Bindaree Beef

Ref: 70Q-13-0318-GCO-516619-0

Bindaree Beef Environmental Impact Statement

Vipac has reviewed the comments received from the NSW EPA dated 22nd May 2014 and this correspondence details our response to the each comment.

Figure 4-2: Site Specific Annual Wind Rose 2002-2006 [TAPM]

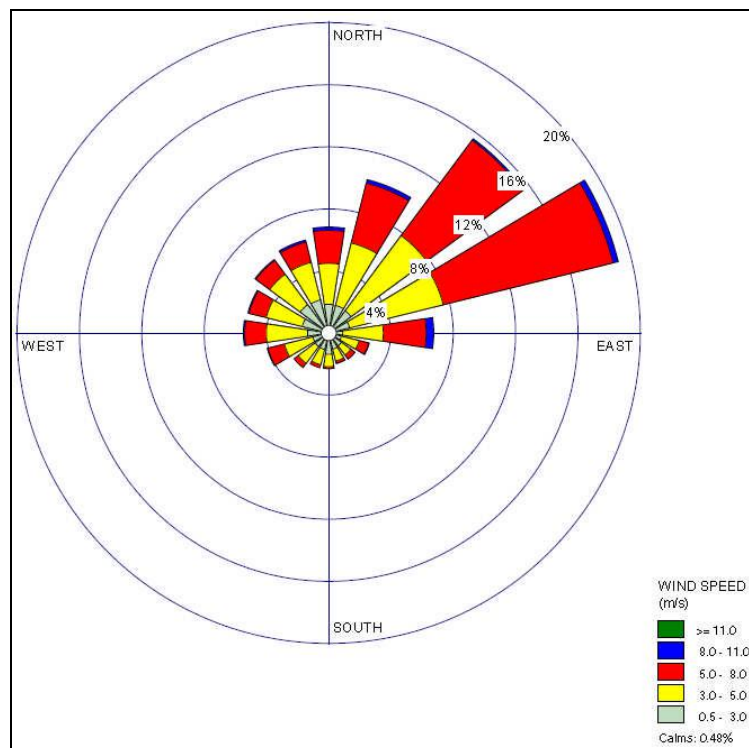
Issue 9 – Wind Rose Data

It has been noted that the 2006 wind roses are different to the 2002-2005 wind roses. The weather conditions (i.e. wind parameters, stability class etc.) for all five years was analysed. The variation in the weather conditions has been taken into consideration during the modelling by predicting noise levels during neutral, prevailing and worst-case weather conditions; as such no additional modelling is required. The variation in wind roses will be discussed in Section 4.3.2 and Section 6 of the report.

Figure 5-1: Noise Logging Locations [Google Earth]

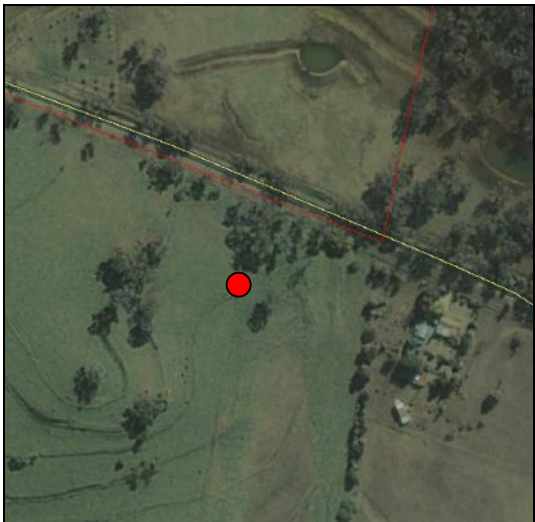
Issue 5 – Background Noise

Noise monitoring was carried out at three locations surrounding the abattoir. The abattoir currently operates 24/7 and this will not change with the new rendering plant and associated facilities. As such, the noise emission from the abattoir does not cease. The new noise sources are similar in nature to the present noise sources (fans, deliveries etc.).

The Industrial Noise Policy details that noise measurements can be made at an alternative site representative of the noise environment of the receptors. However, the 24/7 nature of the plant, other rural noise sources, limited sensitive receptors and the local topography make this approach unsuitable, therefore it was deemed appropriate to keep the abattoir noise included in the data.

For Location 1 the primary noise source is the road traffic which is reflected in the noise monitoring results which identify a higher L_{Aeq} and L_{A90} for each time period. The night time L_{A90} for Location 1 is 1 dB(A) above the value for Monitoring Location 2. This 1 dB(A) increase can be attributed to road traffic noise. Additionally, the monitoring results for Location 3 are much lower than Locations 1 or 2 despite the operations being audible at this location.
